Our reference: DOC13/95208
Contact: Terry Mazzer
Ph: 02 6883 5302

Re: Northparkes Mine Step Change Project (MP 11_0060) Draft Consent Conditions

FIGURE 5.14

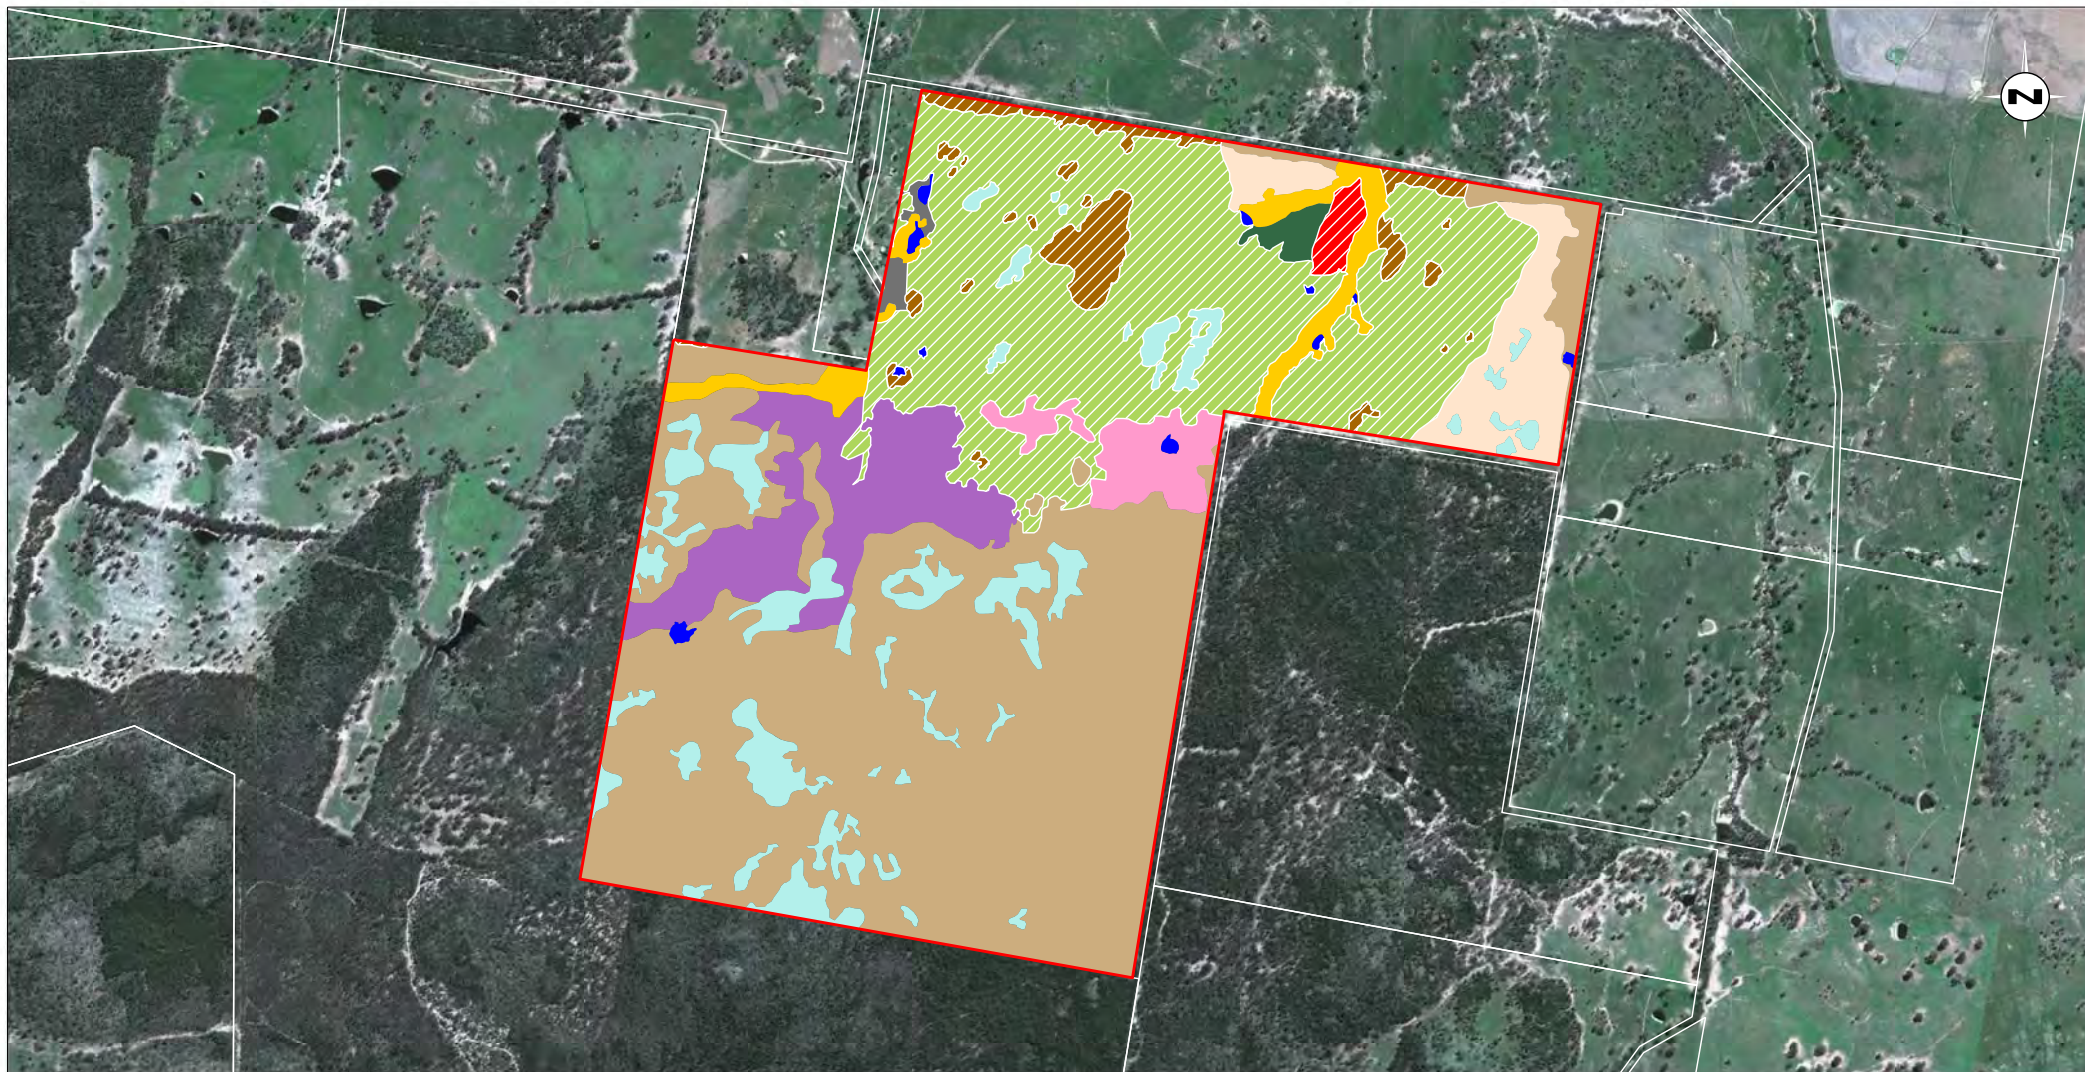
OEH retains concerns with the proposal to reconstruct the Grey Box Grassy Woodland Endangered Ecological Community at Kokoda.. Reconstruction of ecological communities involves high risks and uncertainties for biodiversity outcomes and is generally less preferable than other management strategies, such as enhancing existing habitat. The timeframes required to ensure that reconstruction outcomes are delivered underlie the imperative to have the offset secured in perpetuity with the necessary actions fully resourced.

OEH requests that the approval conditions for this project should include a detailed restoration plan with clear targets and outcomes that will assist in the establishment of an ecologically sustainable Grey Box Grassy Woodland EEC. Targets should be created for ecologically appropriate time periods (eg. 2, 5, 10 years, etc) and the plan should also include contingencies should these outcomes not be achieved, which may include relocating the offset to an alternative offset site.
